From: [REDACTED]
Sent: 09 December 2021 15:42
To: Juan Baeza <Juan.Baeza@arun.gov.uk>
Cc: 'andrew' [REDACTED]
Subject: Application- M/107/21/HH

From: Juan Baeza <Juan.Baeza@arun.gov.uk>
Sent: 09 December 2021 08:54
To: [REDACTED]
Cc: Tim Hickling <Tim.Hickling@arun.gov.uk>
Subject: FW: Committee Report - M/107/21/HH

From: Paul Scamans <Paul.Scamans@arun.gov.uk>
Sent: 08 December 2021 17:18
To: Juan Baeza <Juan.Baeza@arun.gov.uk>
Cc: Tim Hickling <Tim.Hickling@arun.gov.uk>; Kathryn Welch <Kathryn.Welch@arun.gov.uk>
Subject: RE: Committee Report - M/107/21/HH

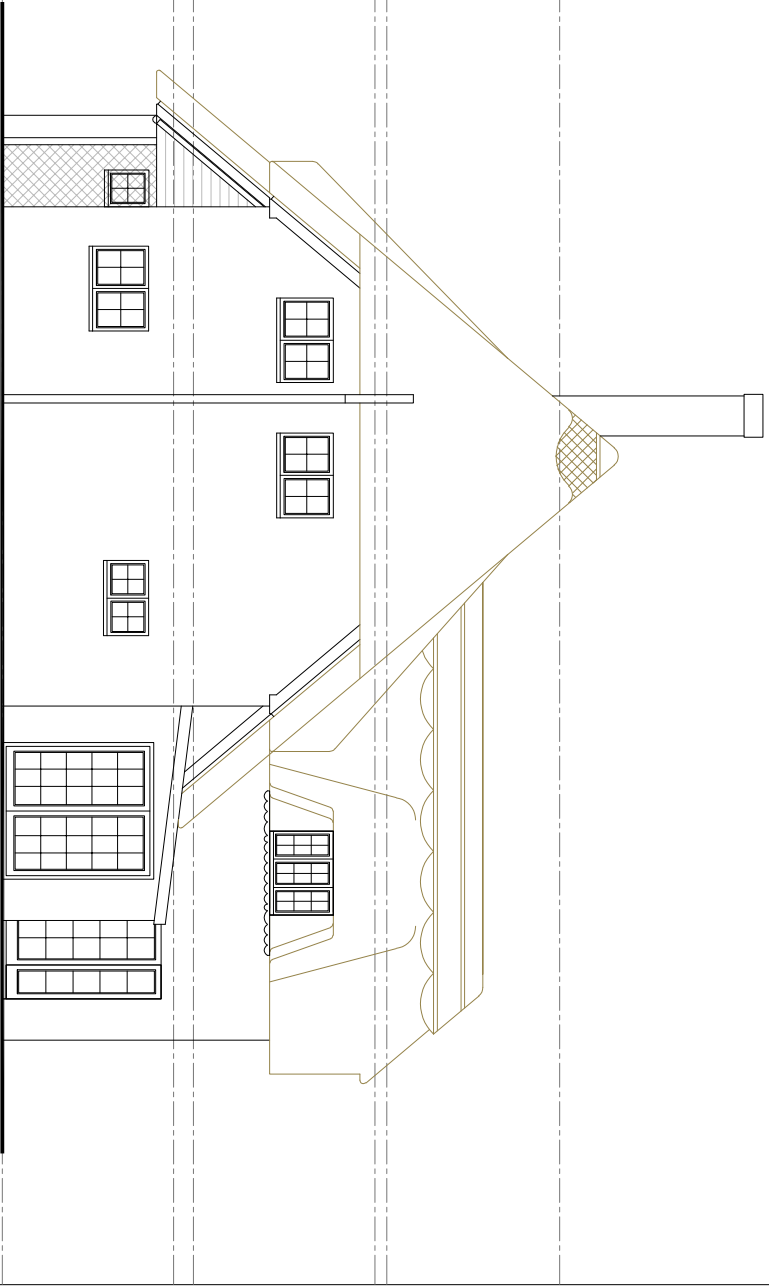
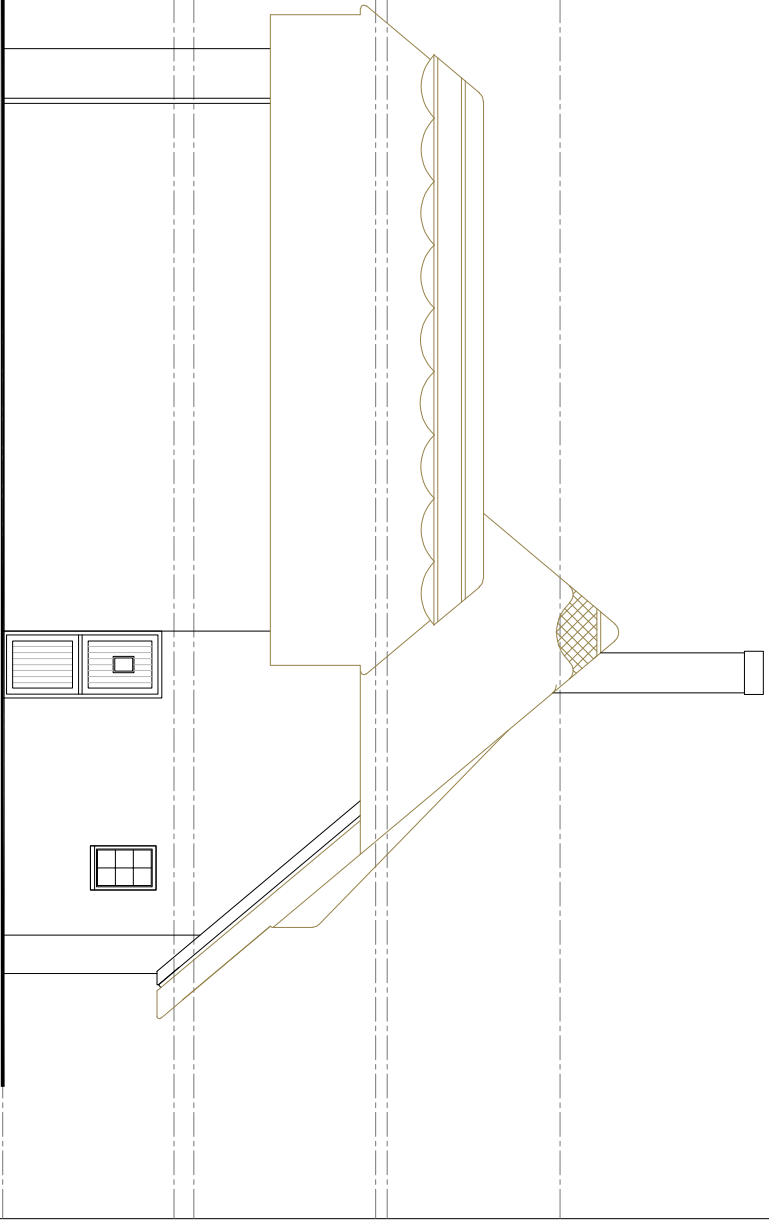
The planners opinion is that a thatched roof on this extension presents a fire hazard for the reasons given by the Surveyor i.e. Whales the potential of an uncontrollable fire hazard. With this in mind if the application was to go to Committee it is likely that Members would refuse planning permission.

Typically buildings with a thatched roof covering with no fire protection should be at least 12m from the boundary.

A building fitted with the Dorset Model has fire resisting separation between the top of the roof structure and the combustible thatch (including various other fire precaution measures).

In this instance a thatched roof with the Dorset Model would be permitted to be used closer to the boundary. However, the following issue would need to be considered.

1. Applying the Dorset Model to just part of a roof would likely be ineffective (unacceptable). A fire would spread in an uncontrolled manner above and below the unprotected roof and compromise the new section of roof – protected above the rafters (see diagram on page 2 of the attached). The guidance states that the barrier must remain unbroken during firefighting (30 minutes fire resistance).

I suggest that you withdraw the application and resubmit a proposal that excludes the use of Thatch.
